From: [REDACTED]
Sent: 04 September 2026 14:43
To: Susan Haley
Subject: RE: EP/33/26/HH - 51 Warren Crescent, East Preston, Littlehampton BN16 1BL- planning
Attachments: A101 rev A existing plans.pdf; A103 rev C existing elevations.pdf; A104 rev D proposed plans.pdf; A105 rev D proposed elevations.pdf

Project	ARCH2026_Waci-R	Sheet
Date	30.06.2026	A101-A
Scale	as stated	
PLANNING ISSUE

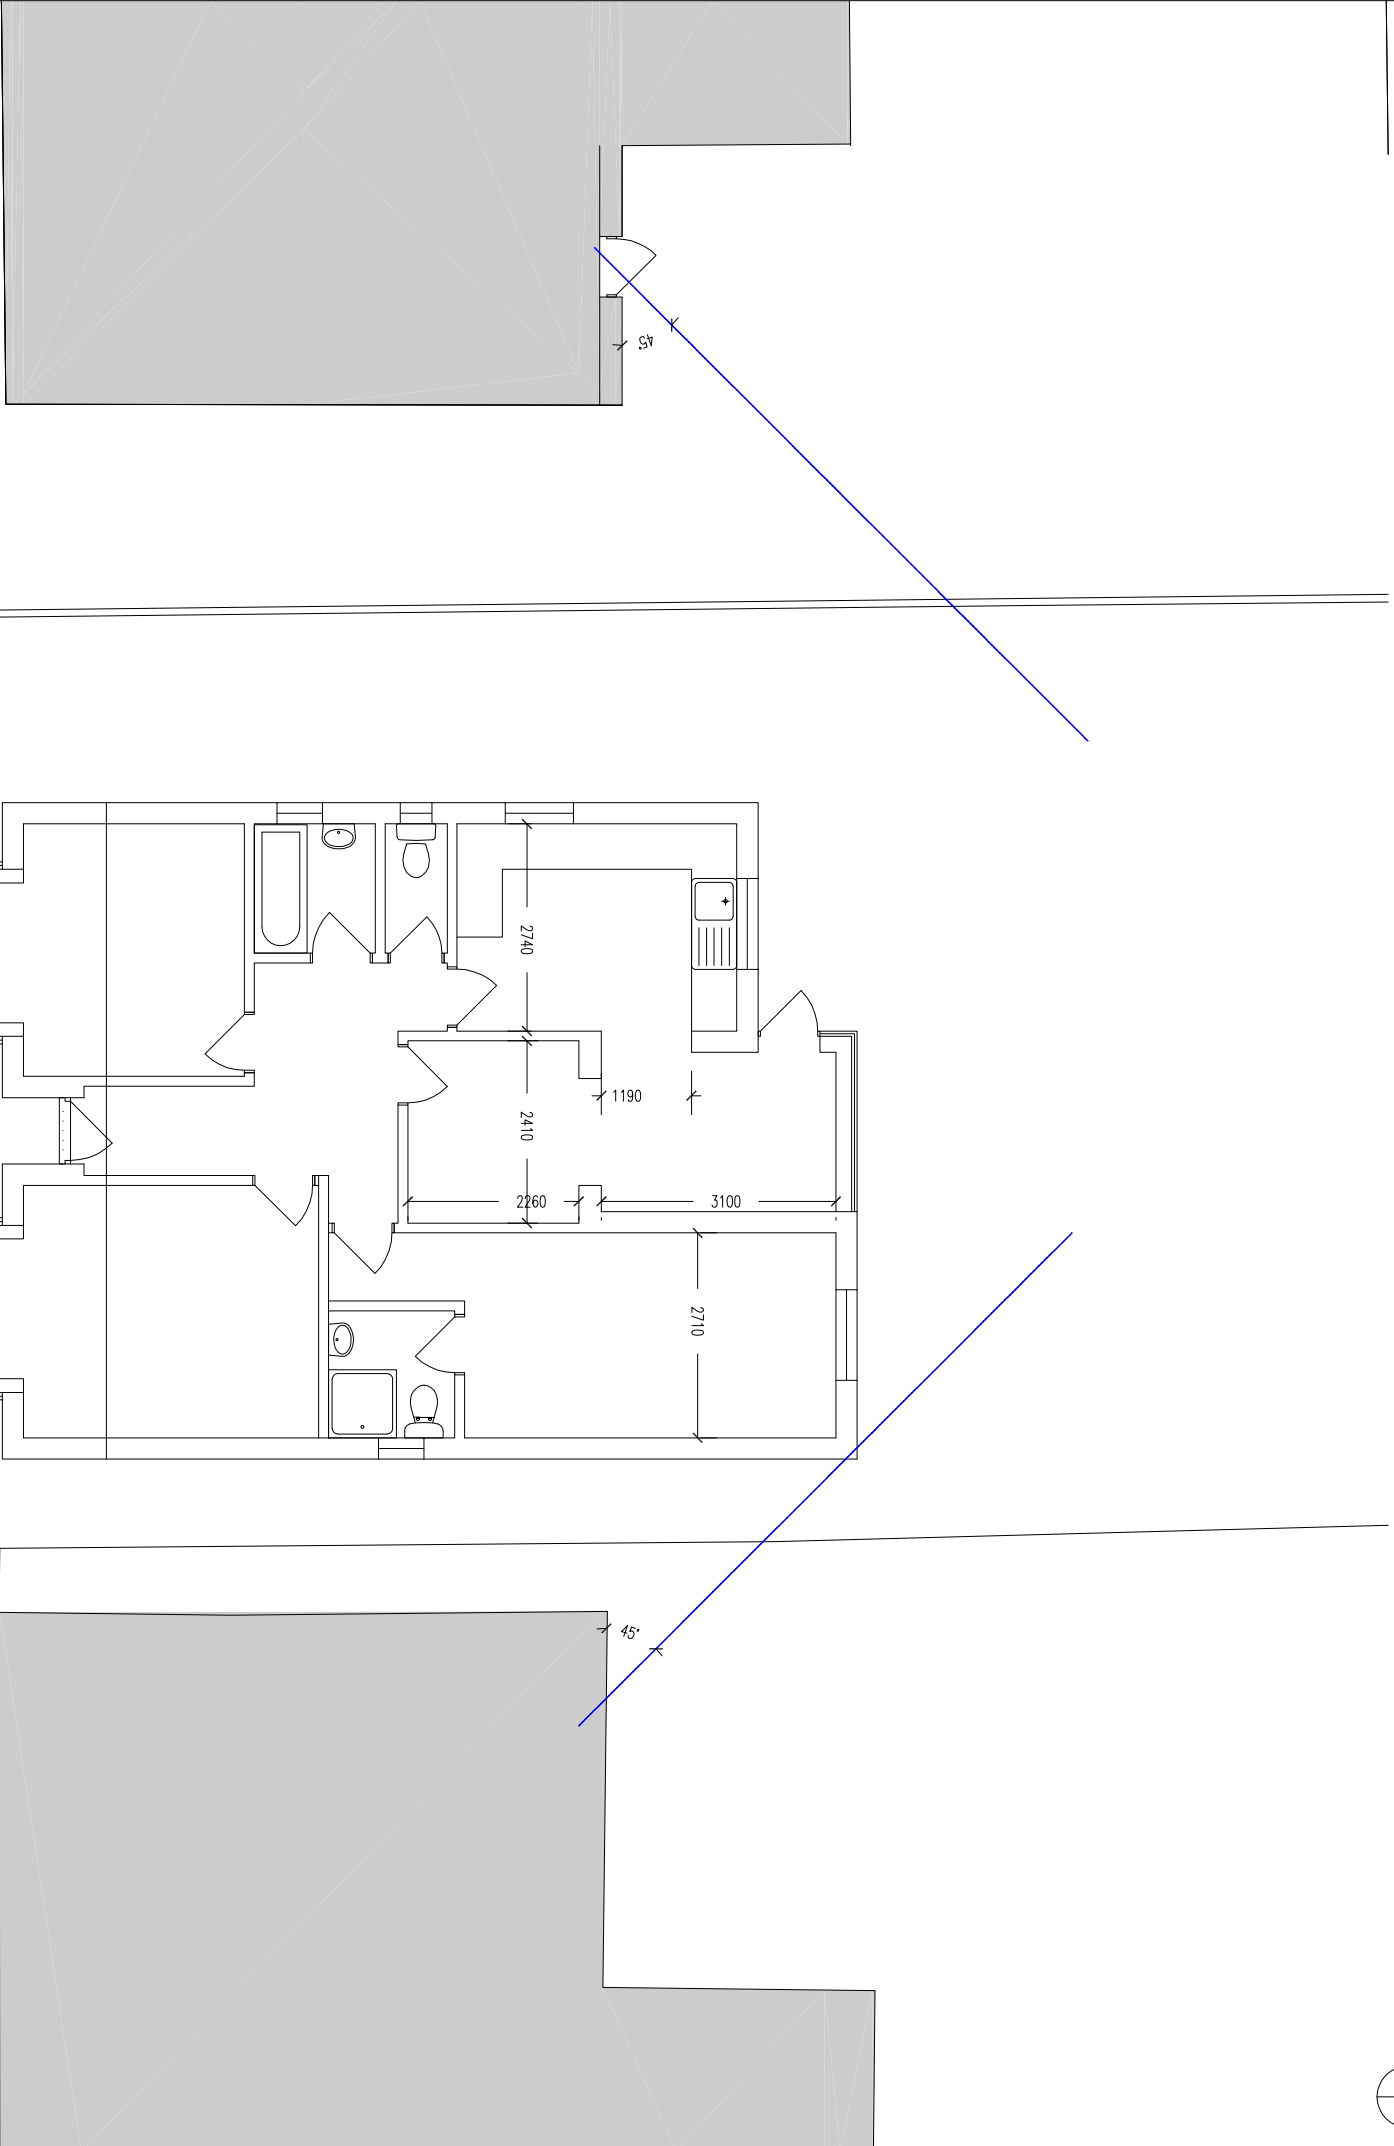
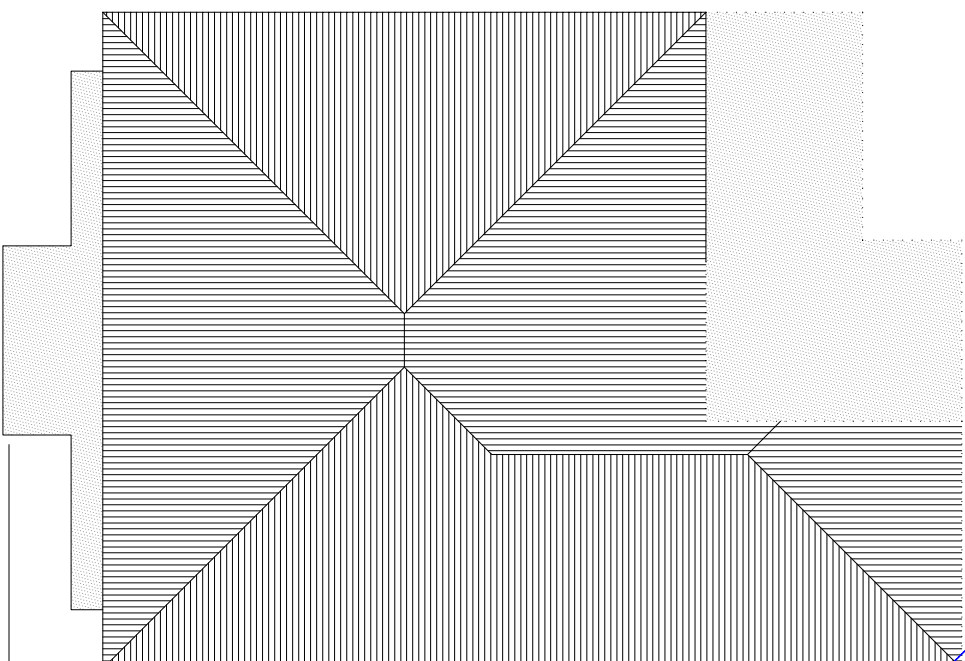
Application EP/71/26/HH- 51 Warren Crescent is still under review, but I would like to ask if you could amend the small typo on the submitted plans which states Warren Close (highlight in blue) and email me updated copies. It refers to the following plans Existing Ground Floor and Roof Plans - A101,

Here are the revised drawings - please add these to the file. I will review the Network Rail comments and get back to you shortly.

Project ARCH2026_WaCl-R	Sheet
Date 30.06.2026	A103-B
Scale as stated	
PRELIMINARY ISSUE

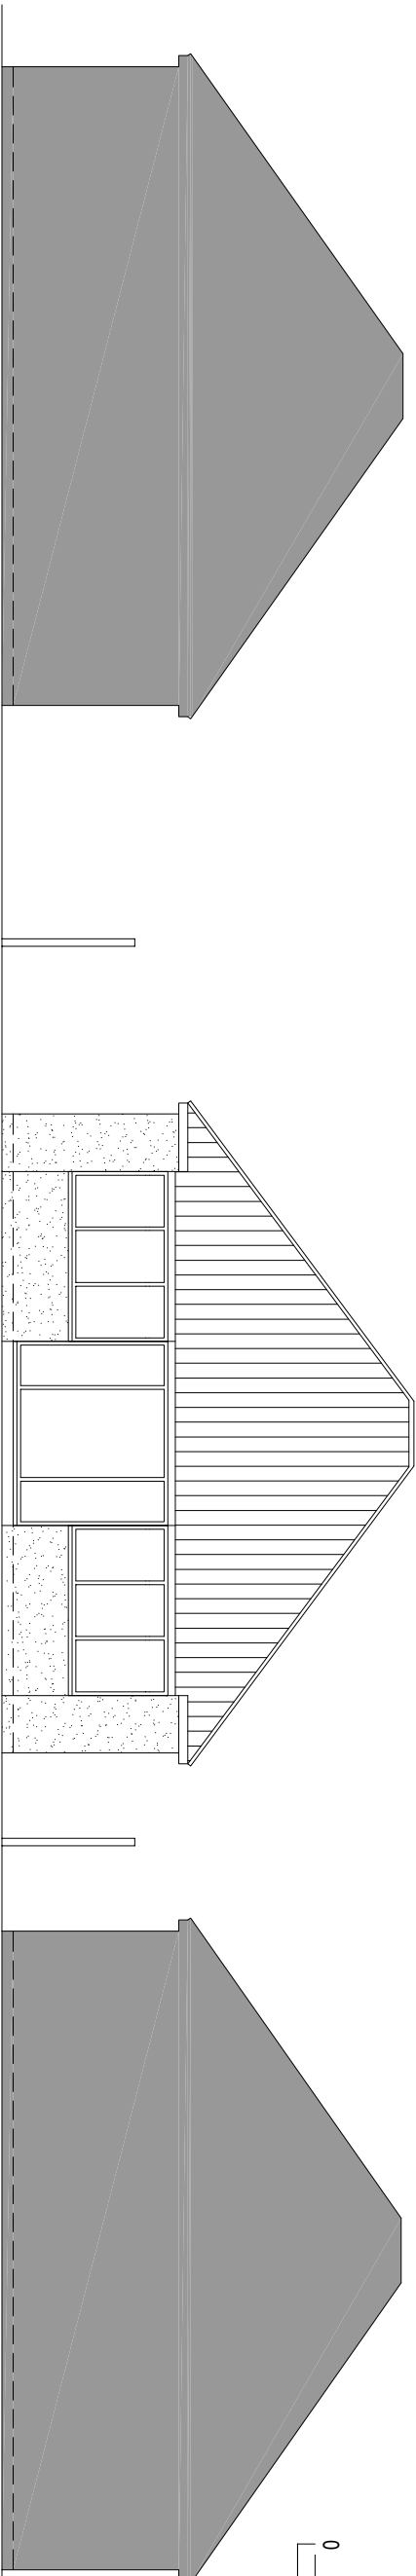
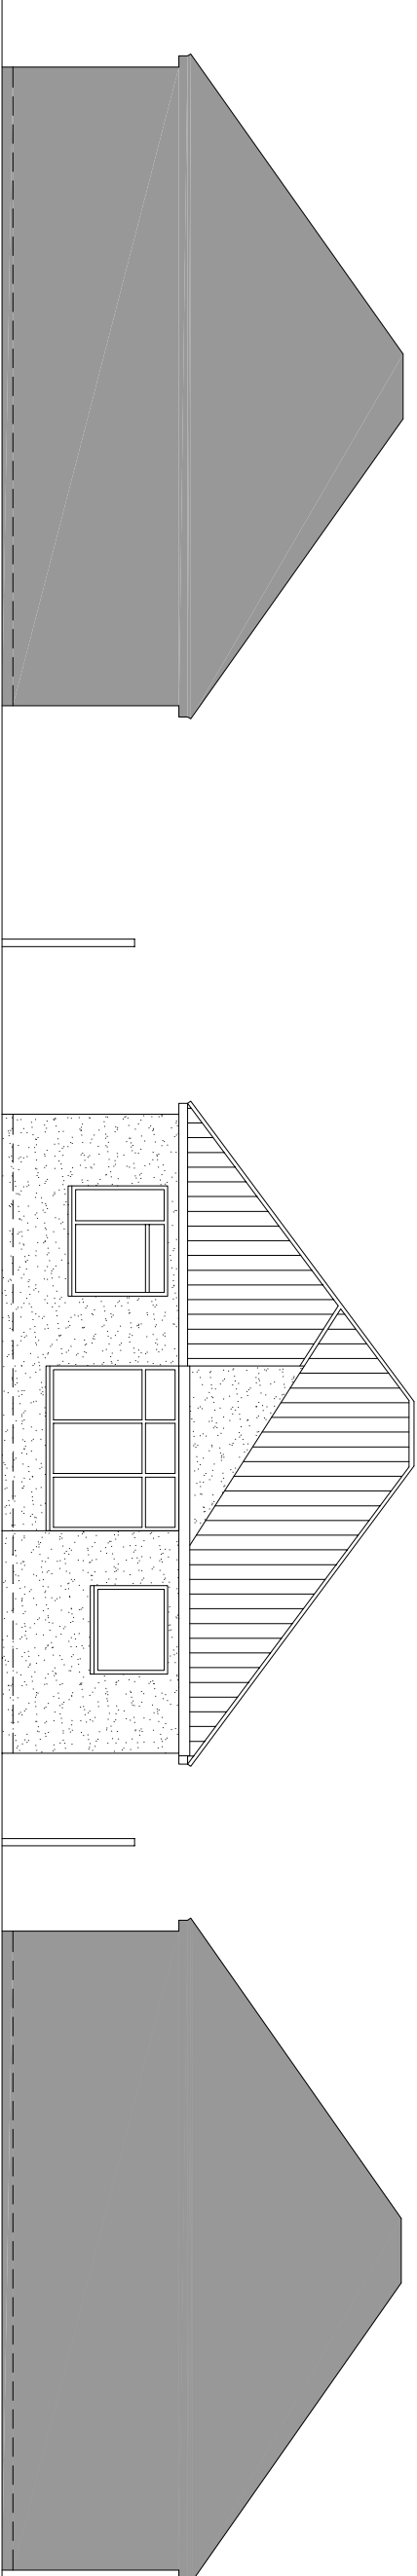
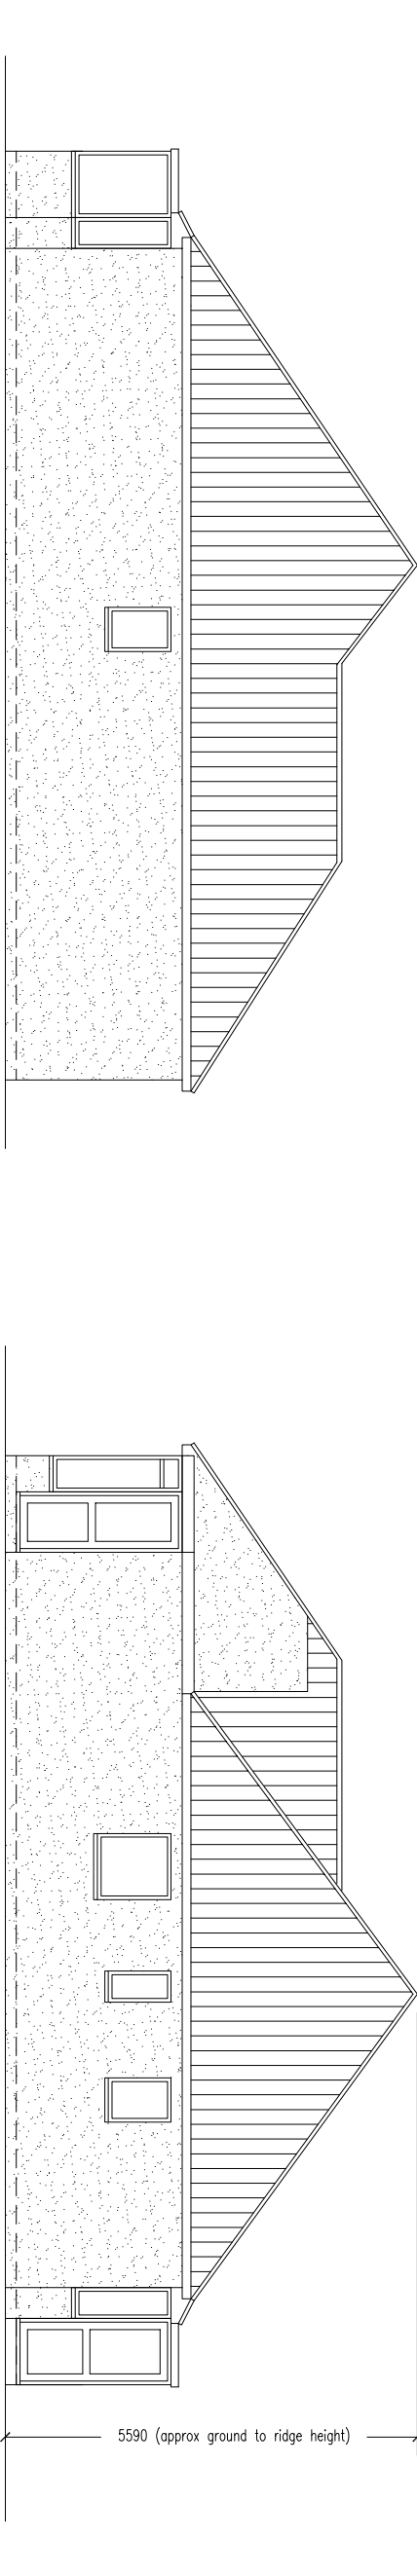
Existing Elevations - A103-B, Proposed Ground Floor, Loft Floor and Roof Plans - A1014-C and Proposed Elevations - A105-C.
